Application Ref:	3/2021/0391	 Ribble Valley Borough Council www.ribblevalley.gov.uk
Date Inspected:	29/06/2021	
Officer:	AB	
DELEGATED ITEM FILE REPORT:		APPROVED

Development Description:	Regularisation of alterations carried out to rear garden area.
Site Address/Location:	14 Waverley Road Ramsgreave BB1 9BN

DRG NUMBER : UC21-05-788 DRG 02

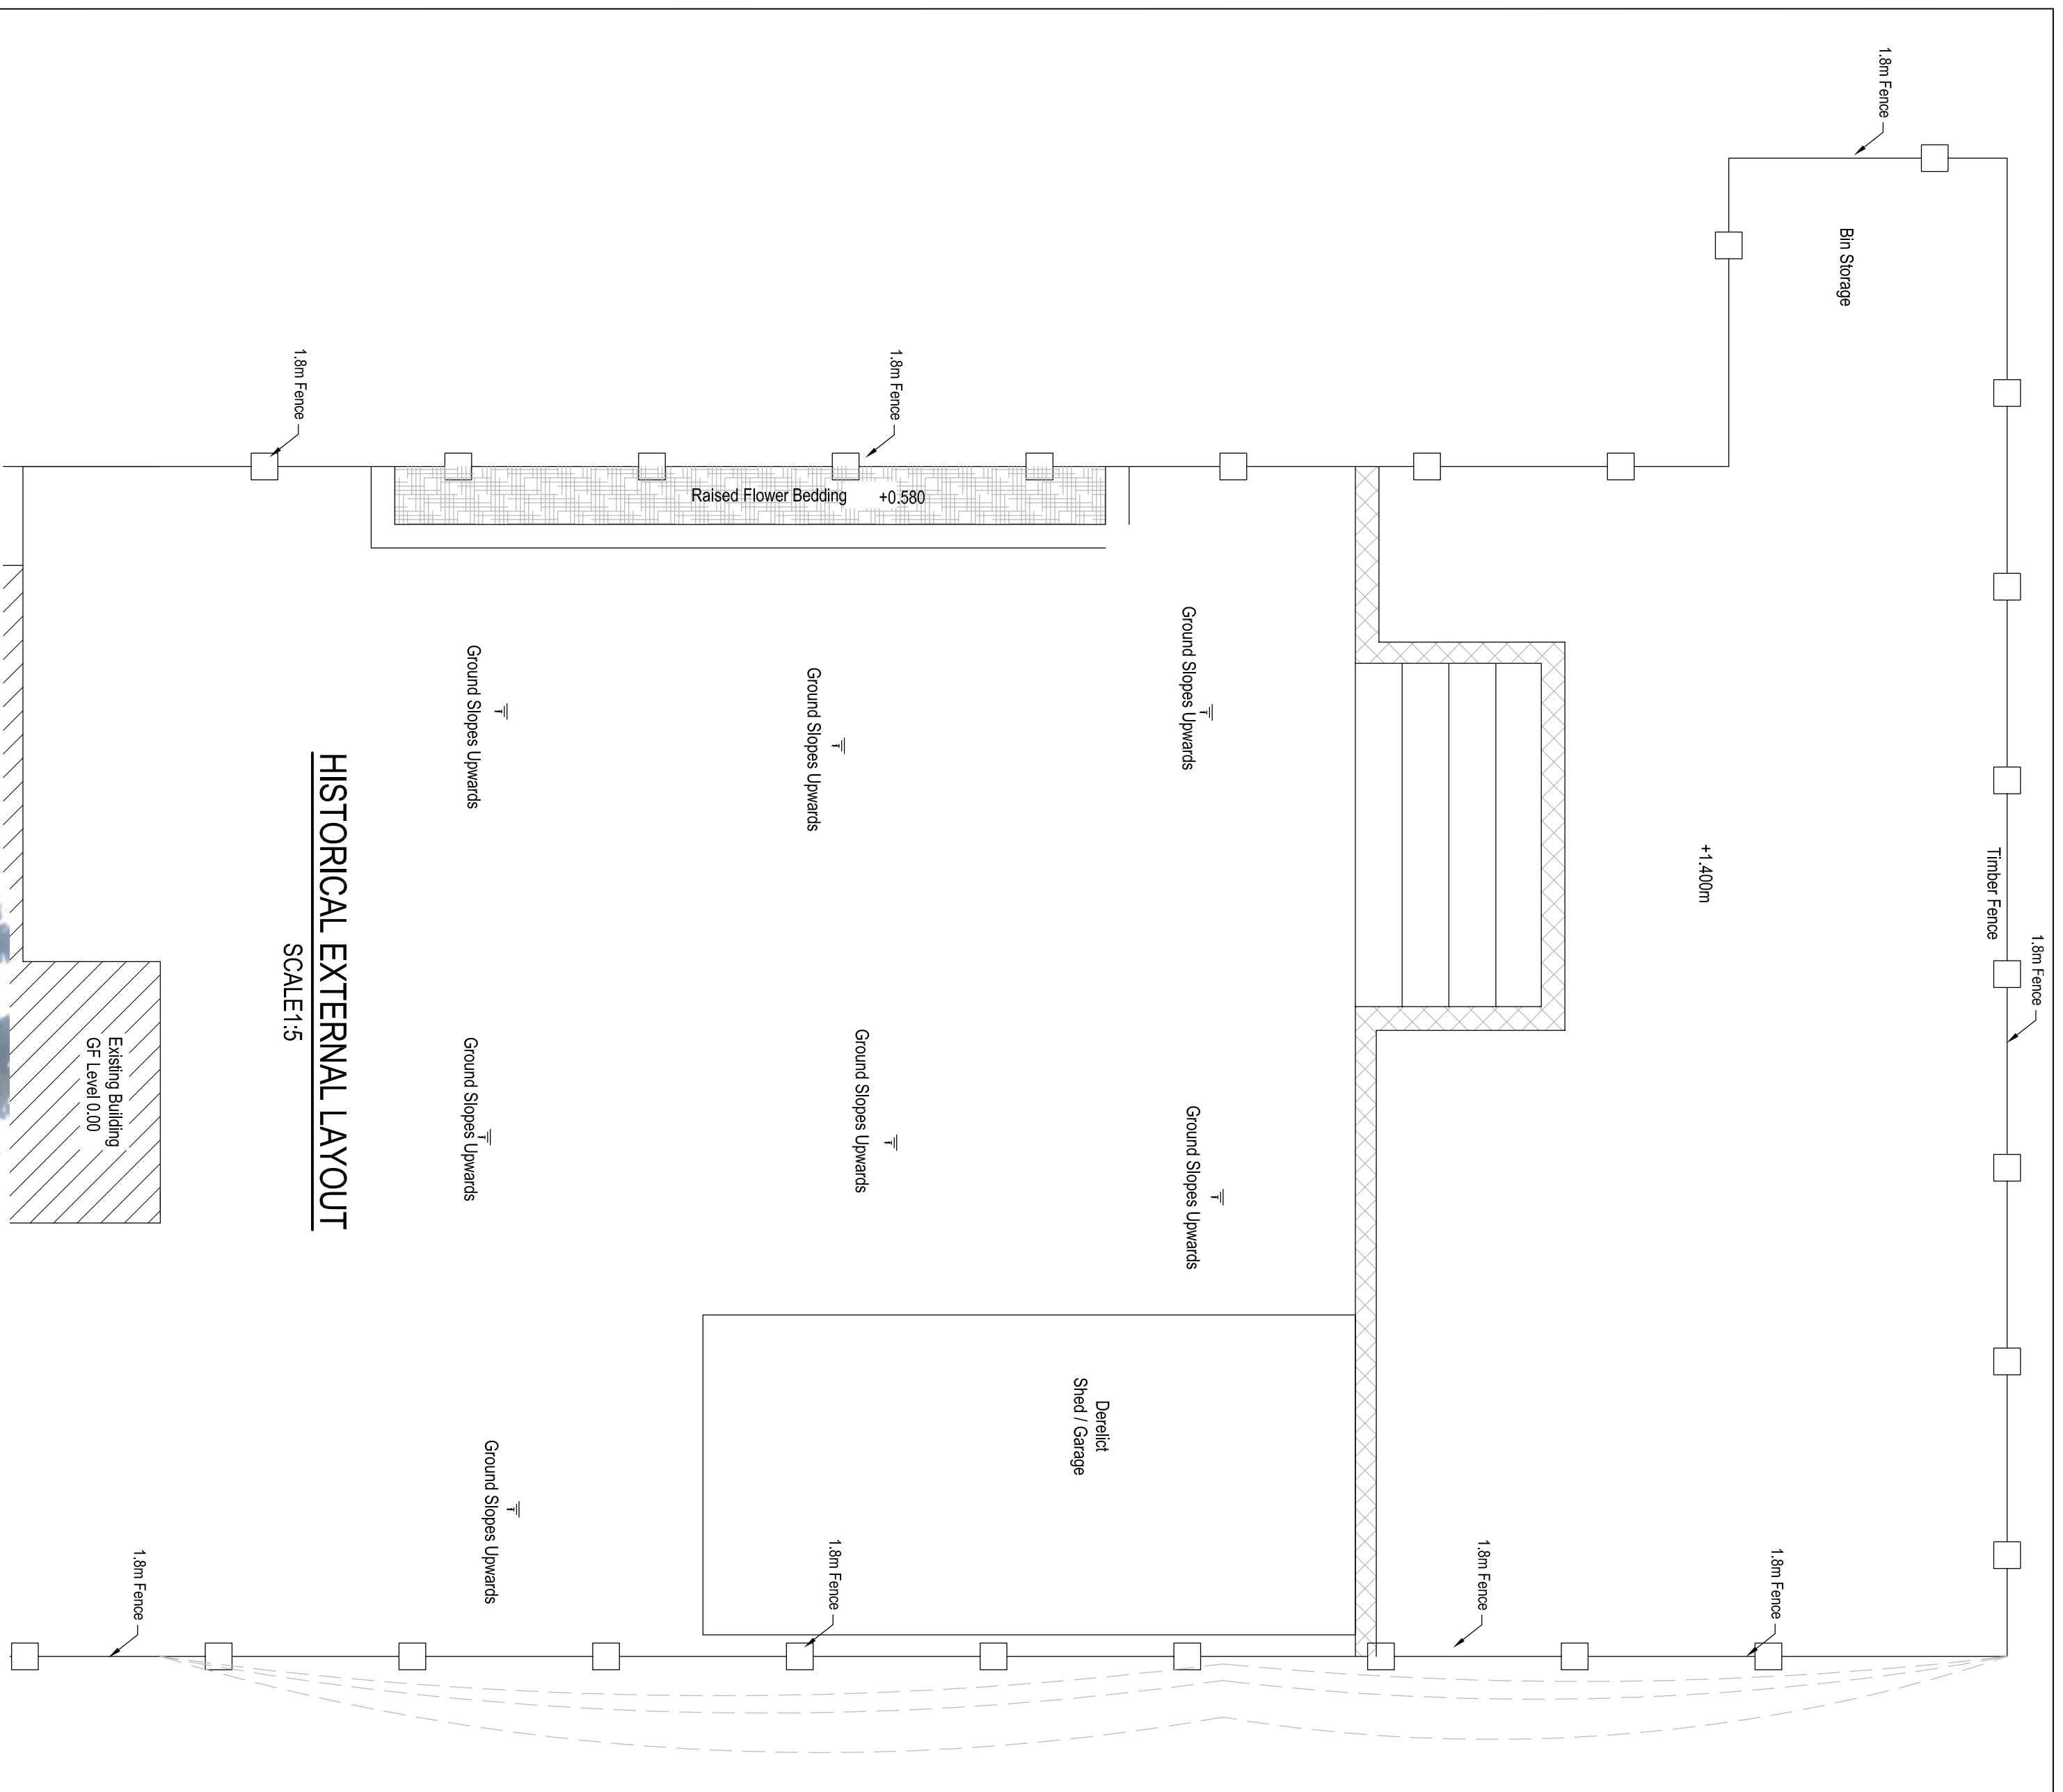
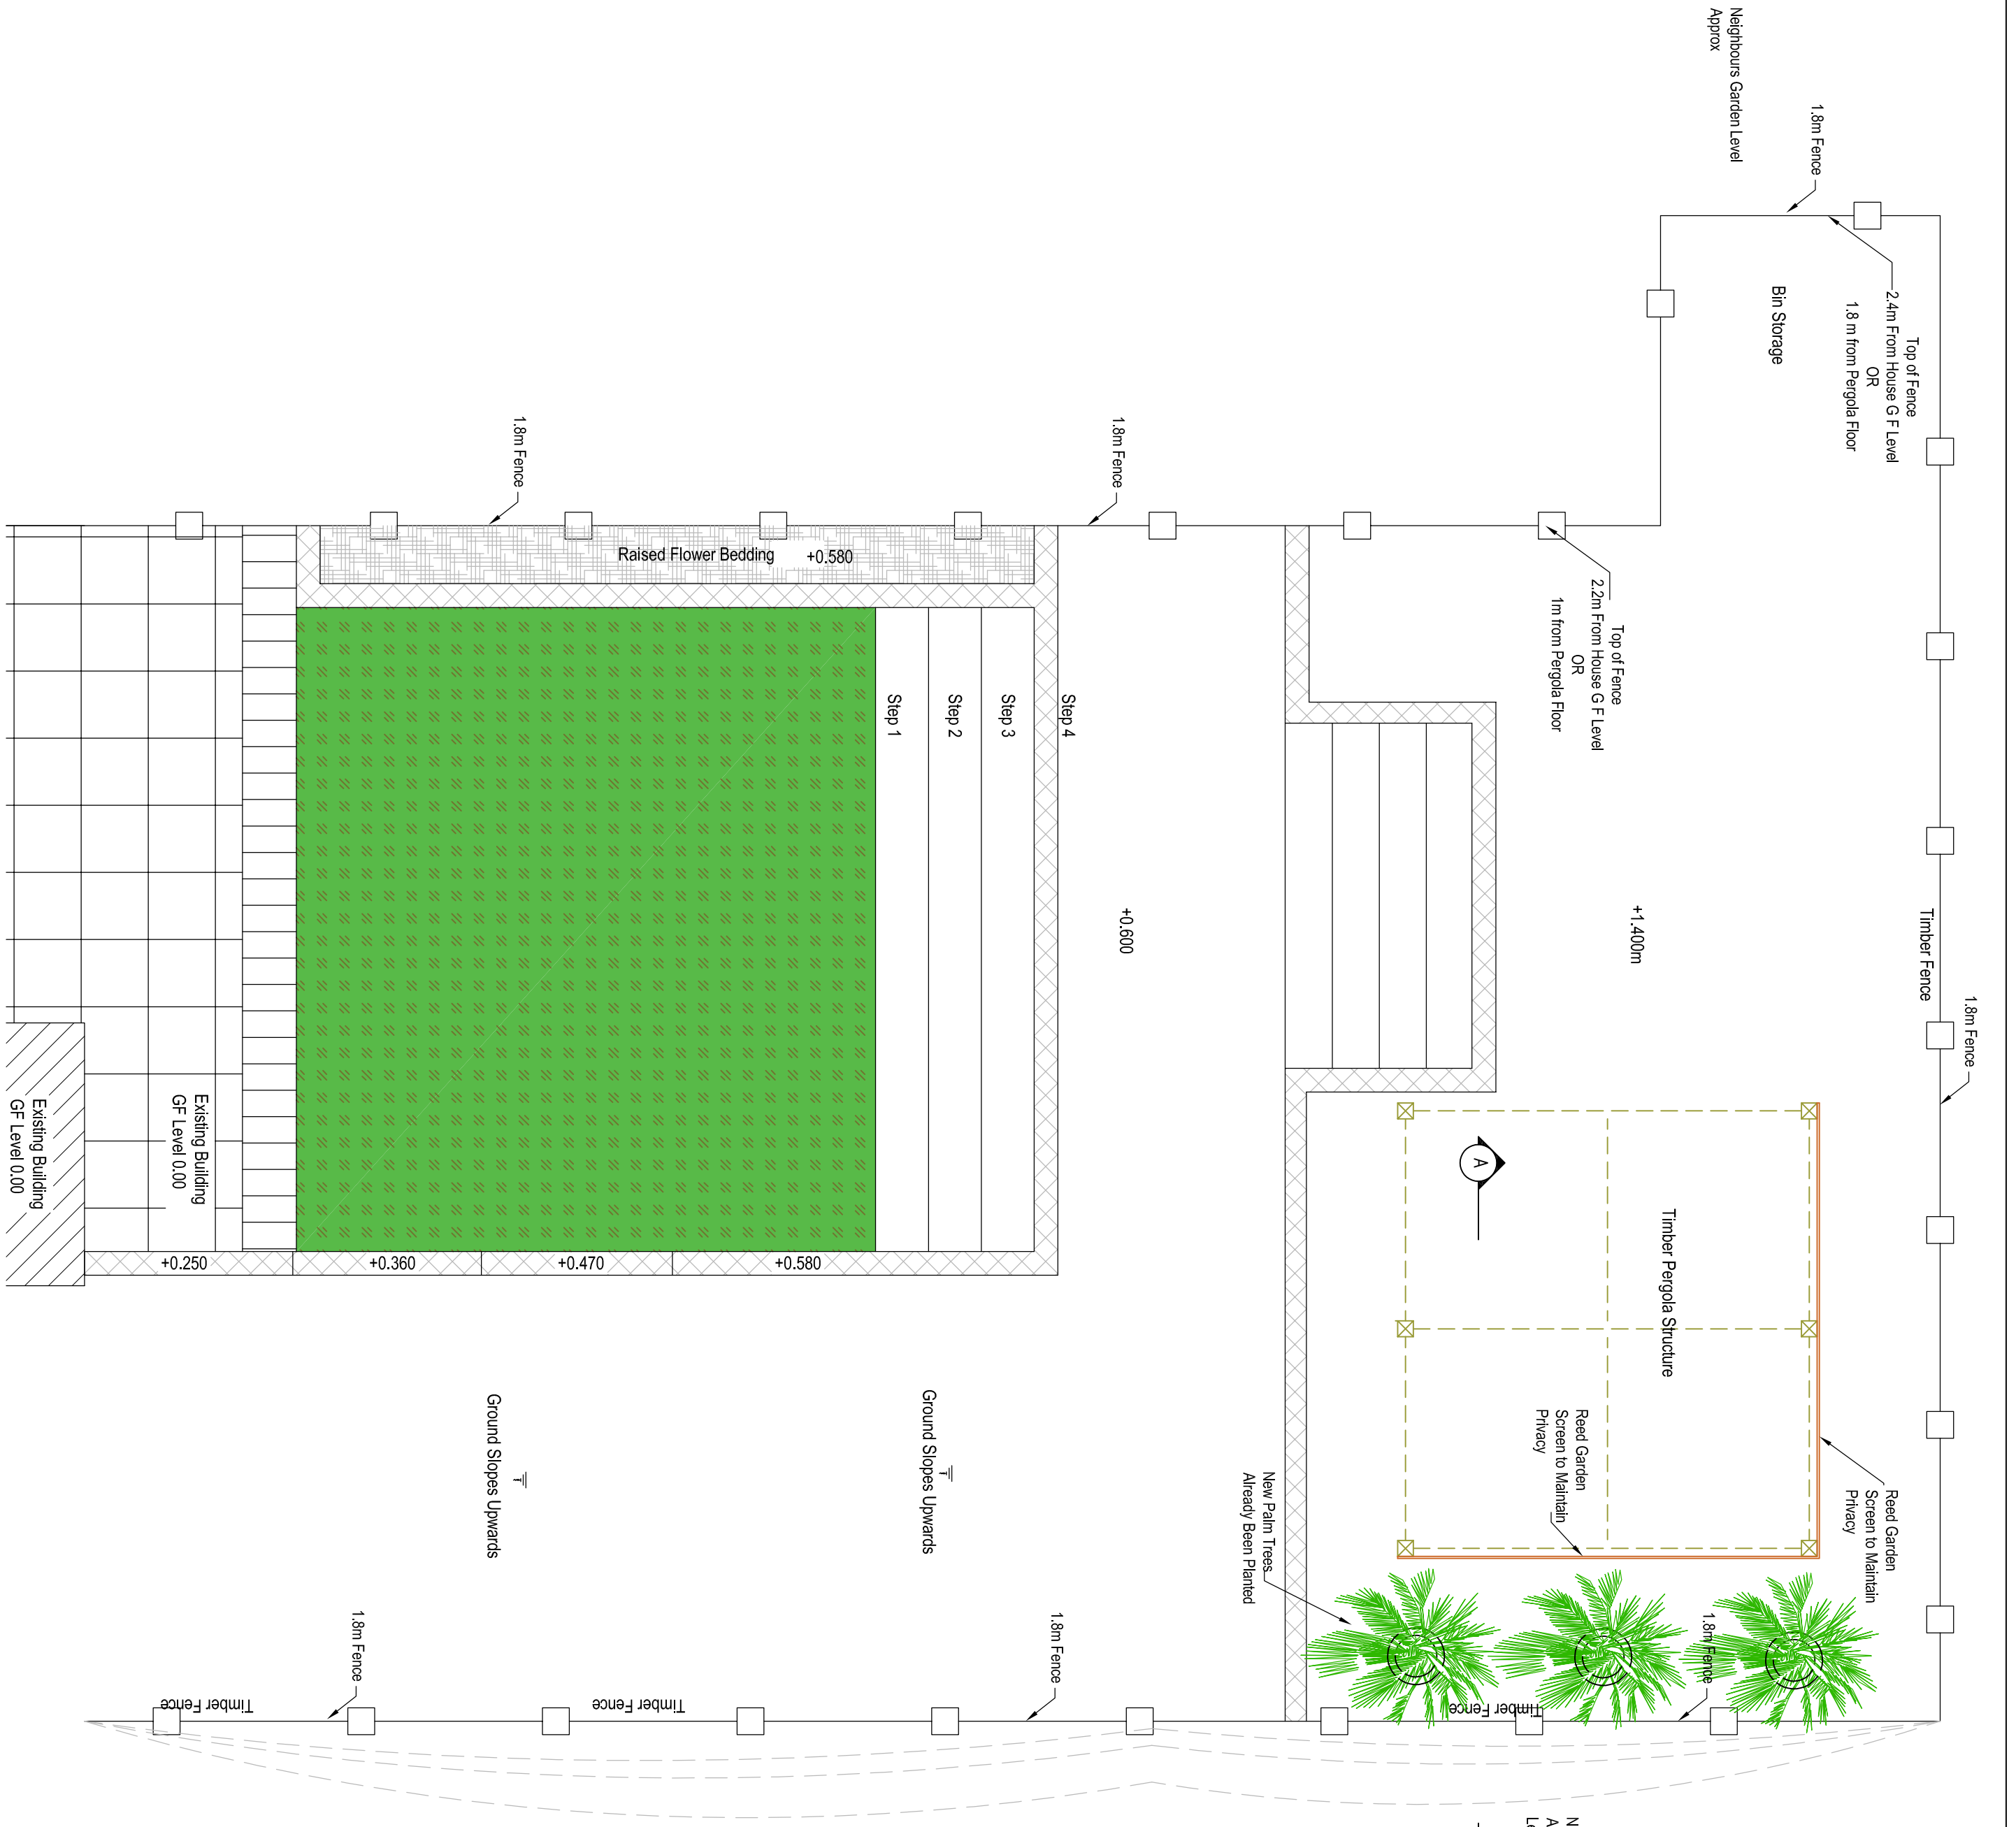
CONSULTATIONS:	Parish/Town Council
None received.	
CONSULTATIONS:	Additional Representations.
One letter of objection has been received and raises the following concerns: • The submitted plans indicating the previous site are inaccurate and misleading; • The development has resulted in overlooking and loss of privacy. Two letters of support have also been received.

In assessing the impact of the development, it is important to understand the previous position in respect of land levels within the application site. According to the applicant, land levels have not been raised as there was an existing raised level in this location previously. Old stone walls have been removed and simply replaced with stronger retaining walls.

Regarding levels to the rear of the site, it does not appear that land has been raised notably at this point due the consistent height of the land when measured against the concrete panels of the rear fence as shown on submitted before and after photos. However, objectors have provided a range of information to demonstrate the previous site layout. Taking this into account it is considered that, on the basis of probability, the raised area of land to the rear of the application site has been considerably extended to create a large level platform that would provide unrestricted, elevated views into the neighbouring garden of 16 Waverley Road.
